OXFORDSHIRE COUNTY COUNCIL'S RESPONSE TO CONSULTATION ON THE FOLLOWING DEVELOPMENT PROPOSAL

Application no: 23/03073/HYBRID

Proposal: In FULL, the construction of an 82-apartment affordable extra care home (C2 use class) with associated openspace / green infrastructure, landscaping, car / cycle parking, service infrastructure (drainage, highways, lighting), engineering operations, creation of new vehicular access and re-instatement of existing access to footpath, and in OUTLINE, the construction of up to 14 residential (C3 use class) dwellings with associated landscaping, service infrastructure (highways, drainage, lighting)

Location: Phase 2 SW Bicester Kingsmere Parcel R East Of, Ludlow Road, Bicester

Drawing No: 21413-CWA-BC-XX-DR-A-2011

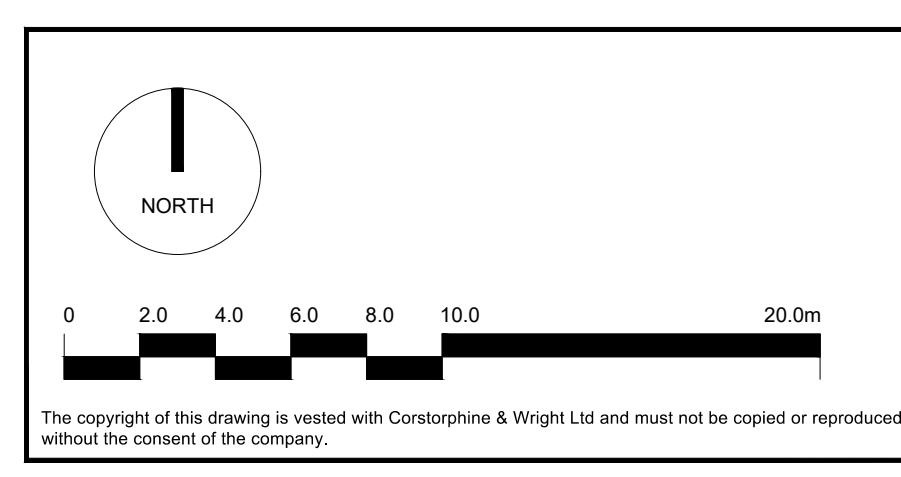
The amendments to the layout plan in relation to aisle widths in order to better facilitated two-way vehicle movement is noted.

A pedestrian / cycle link to the northwest of the site (near the turning head / substation), connecting to the residential access should be provided / suitably conditioned.

It is noted that the trees are proposed to be located outside of the visibility splay. It should be conditioned that the visibility splay should be free of obstructions 2m high down to a point 600mm above the carriageway.

The OCC Highways Agreement team have requested the specific plans detailed in the Road Safety Audit (dwg no. 21413-CWA-BC-XX-DR-A-2011 P15).

The drawing contained within the revised note is revision reference P25 not P15. There is also another plan with revision reference P26. Clarification is sought as to the final plan version. Without seeing the plans used within the audit they are unable to confirm / agree with the outcomes of the audit.
